Application No: BR/60/26/HH
Site Address: 71 Longford Road Bognor Regis PO21 1AE
Description of works: Retrospective application for conversion of former detached garage to an annexe, including raising of the ridgeline.

Thank you for your internet representation made on 18th May 2026 which has been recorded as an objection with the comments as follows:

Proposed

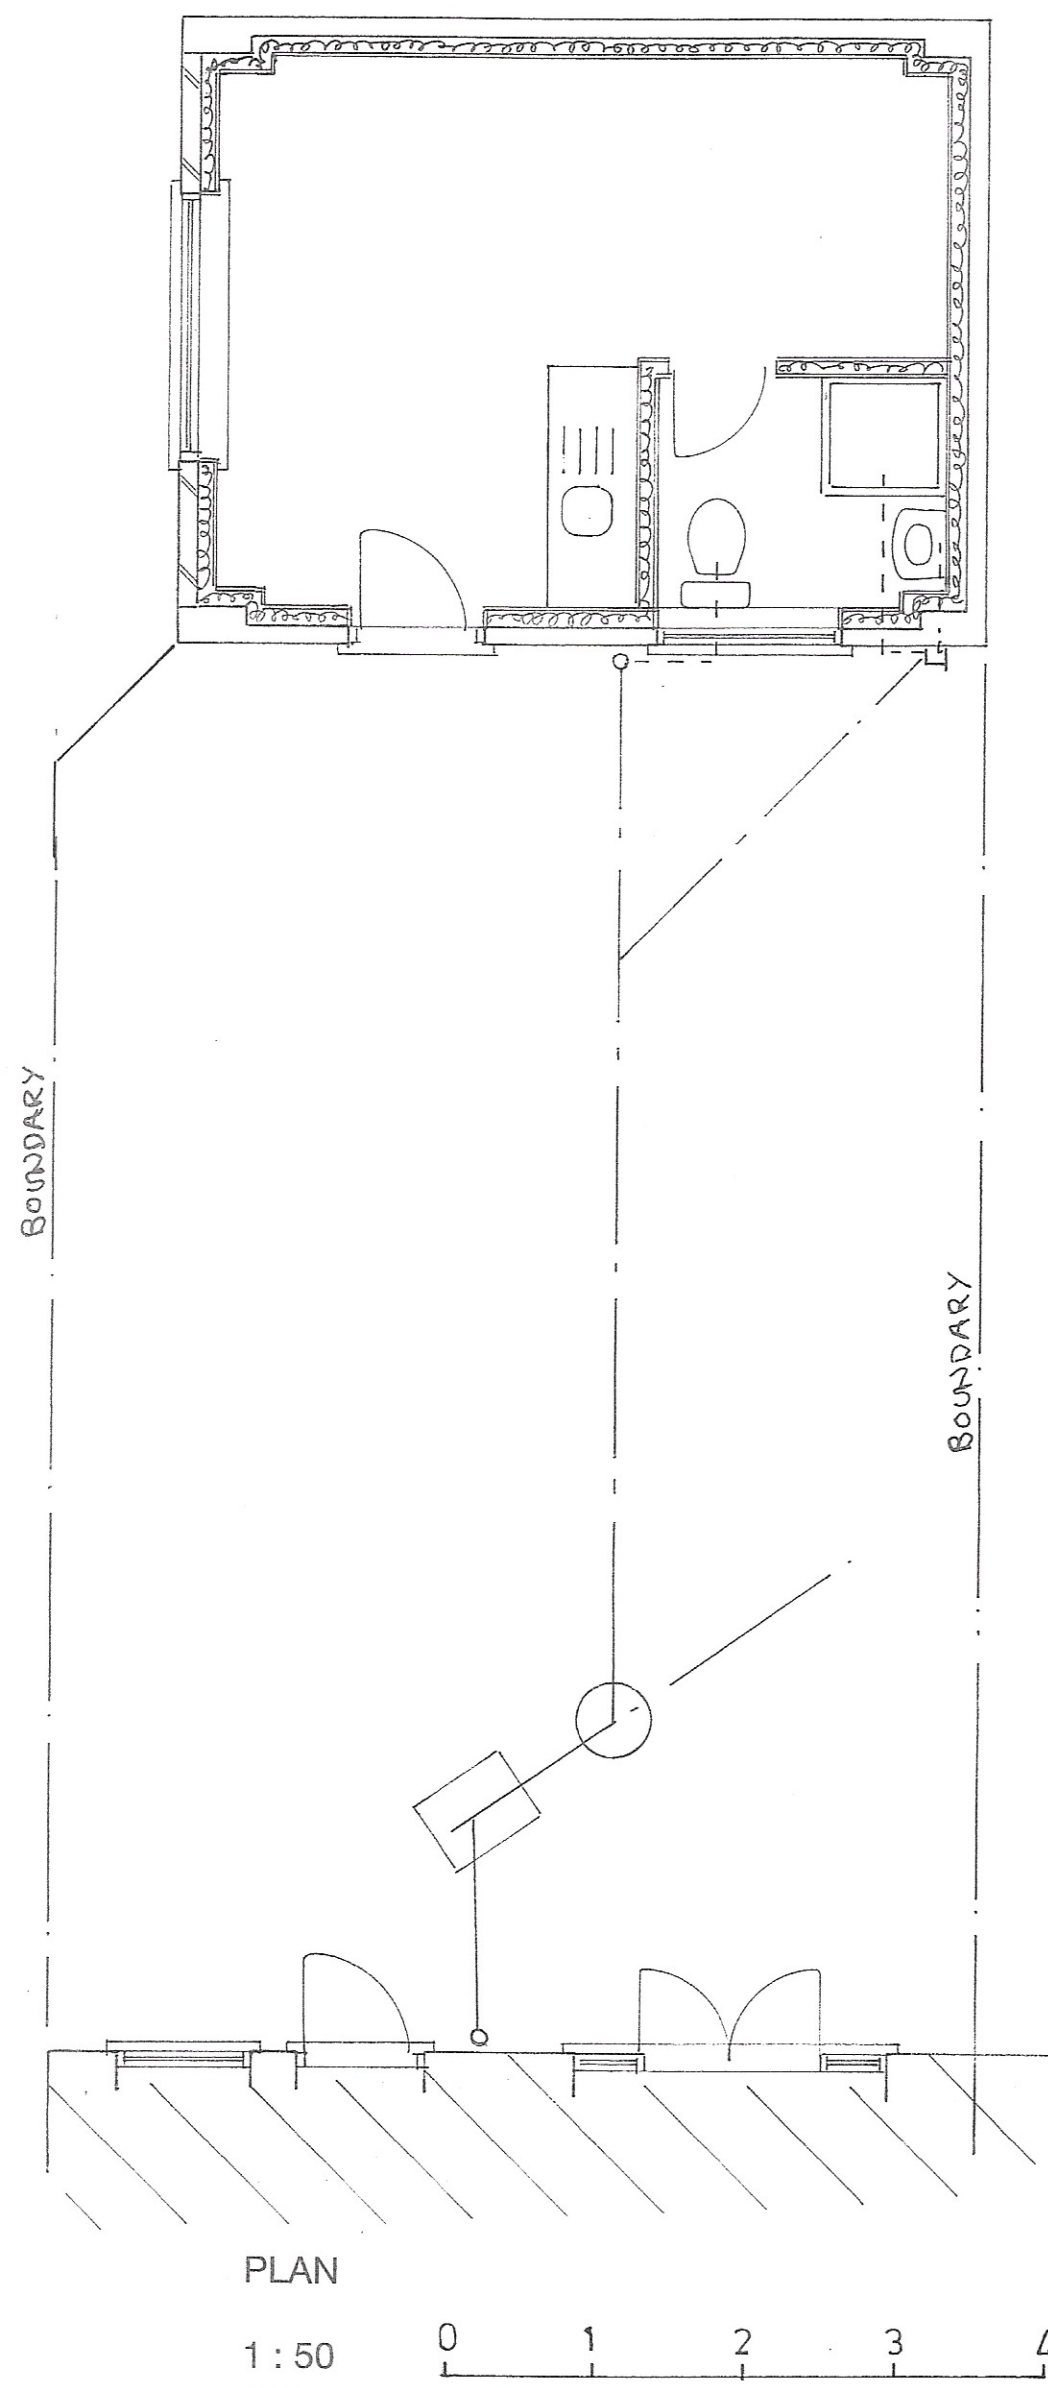
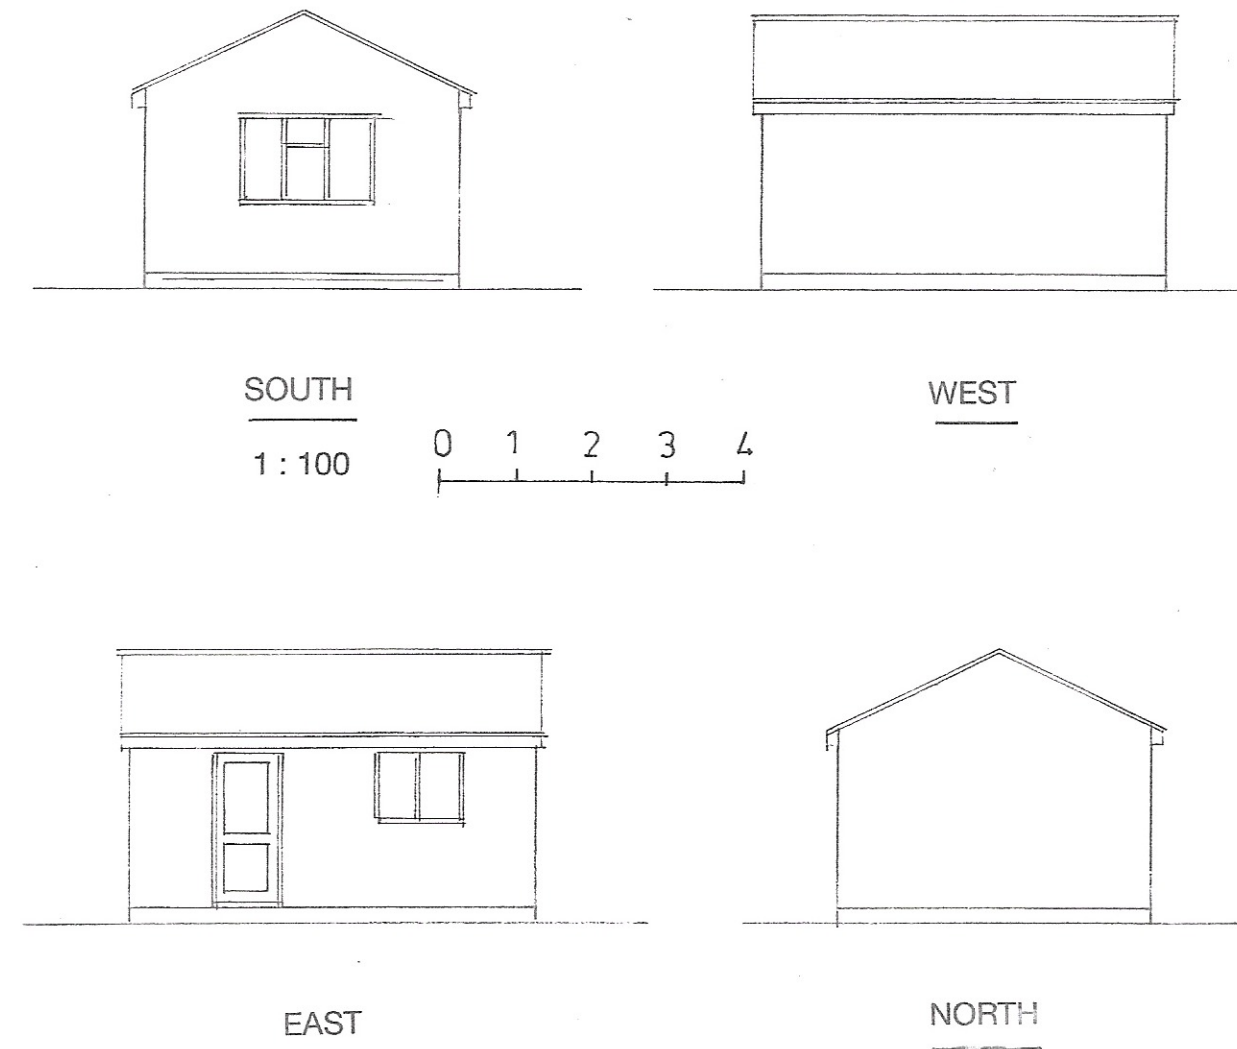
There is currently no access to the garage on the east elevation even though it has been illustrated on the plans but on the south elevation.

The plans on the application do not show the mezzanine floor for the sleeping space which is currently installed within the garage and skylights are not shown on the eastern elevation.

If permission is granted then the access should be on the east elevation as per the drawings and not on the south elevation.
